**WEST SUSSEX COUNTY COUNCIL
STRATEGIC PLANNING CONSULTATION**

SUBJECT: A/11/17/OUT

Hybrid Application to include Full planning permission for a retail unit (Class A1) comprising 1,487sqm with associated access, car parking, servicing, landscaping & associated works & Outline planning permission with some matters reserved (scale & appearance) for public house (Class A4) comprising 581sqm (resubmission following A/23/15/OUT).

Land south of, New Road (A259) & East of Brook, Angmering

Drawing Title  
**PLANNING: SITE PLAN**

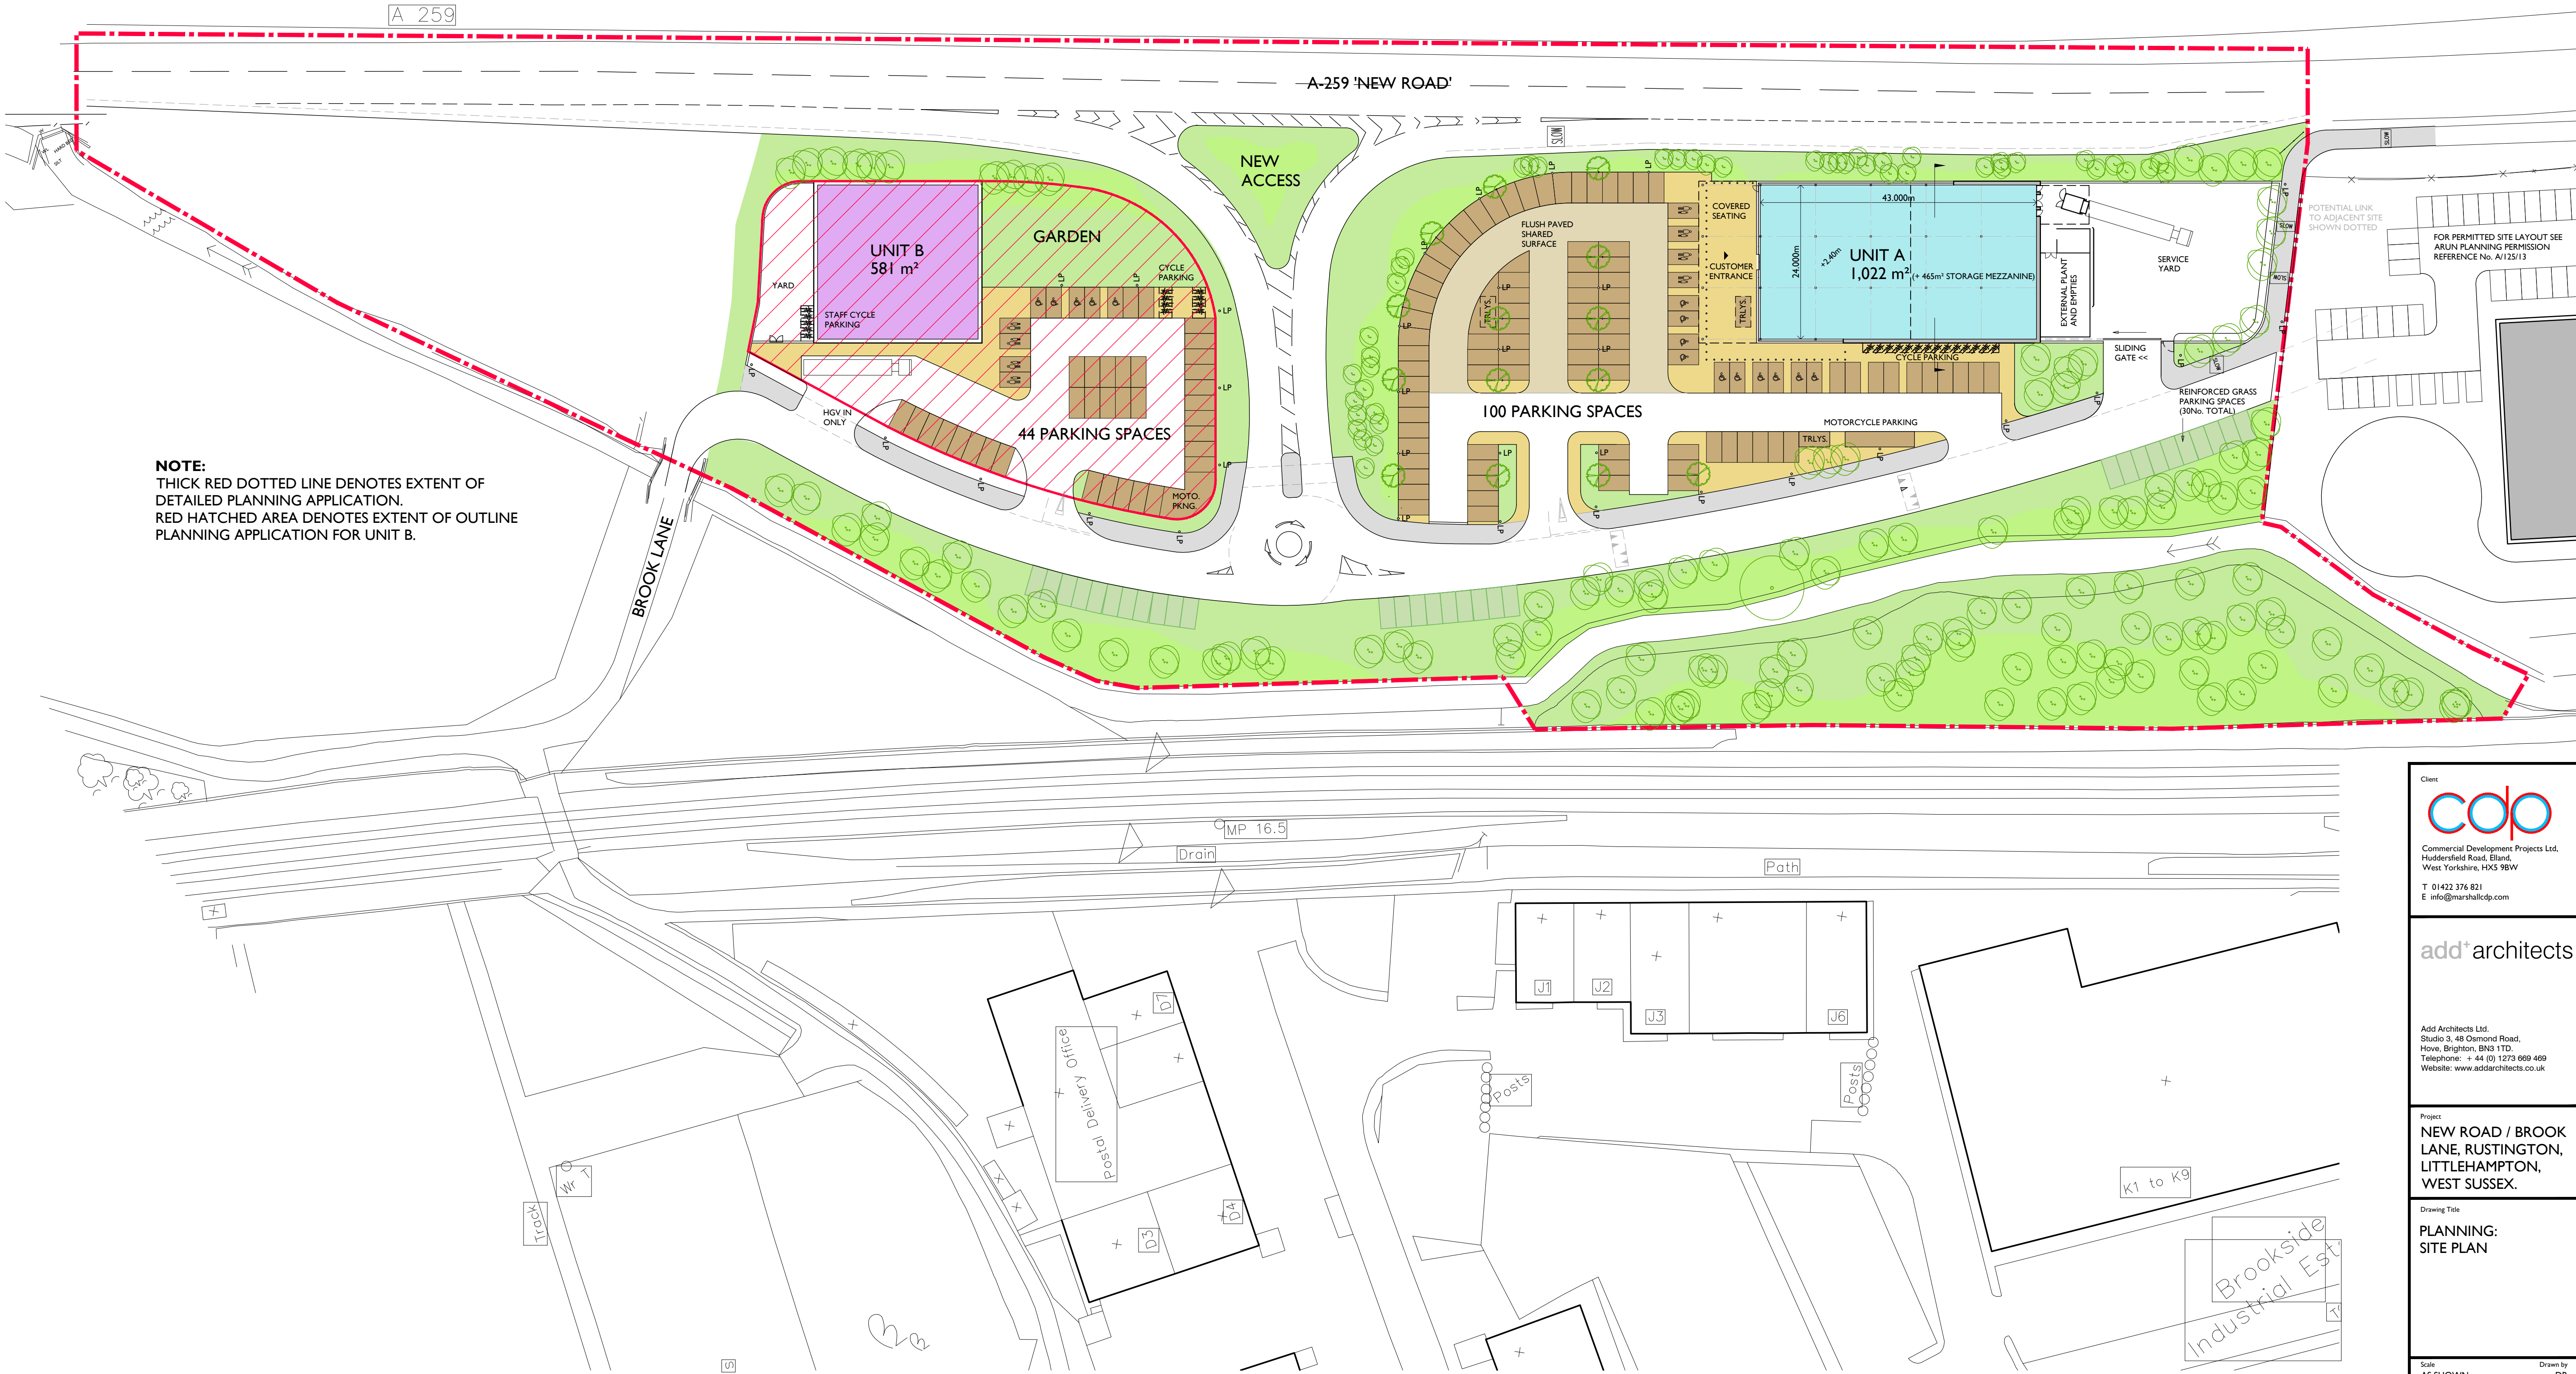
West Sussex County Council, in its capacity as the Local Highway Authority, has been consulted on the proposed development on land south of the A259. This is a resubmission of consent A/23/15 and seeks for the provision of alternative access arrangements.

The application is supported by both a Transport Assessment and Stage 1 Road Safety Audit. The Audit raises a number of problems, a number of which would be resolved as part of any future detailed design (i.e. provision of road markings and signage). However, the Auditor has identified a problem relating to the spacing of the junction directly to the east of the site, and the potential for conflict between vehicles emerging and accelerating from this access and vehicles decelerating and accessing the application site. In accordance with Highway Directive 19/15 and the WSCC Road Safety Audit Policy, any RSA should be accompanied to a Designer Response addressing the problems raised by the Auditor. A Designer Response has not been provided, and the problem identified remains unresolved.

In addition, the LHA requires the submission of a Design Audit, setting out compliance (or otherwise) with Design Manual for Roads and Bridges Standards.

The LHA consider that the Applicant has not demonstrated that safe and suitable access can be achieved, contrary to paragraph 32 of the National Planning Policy Framework.
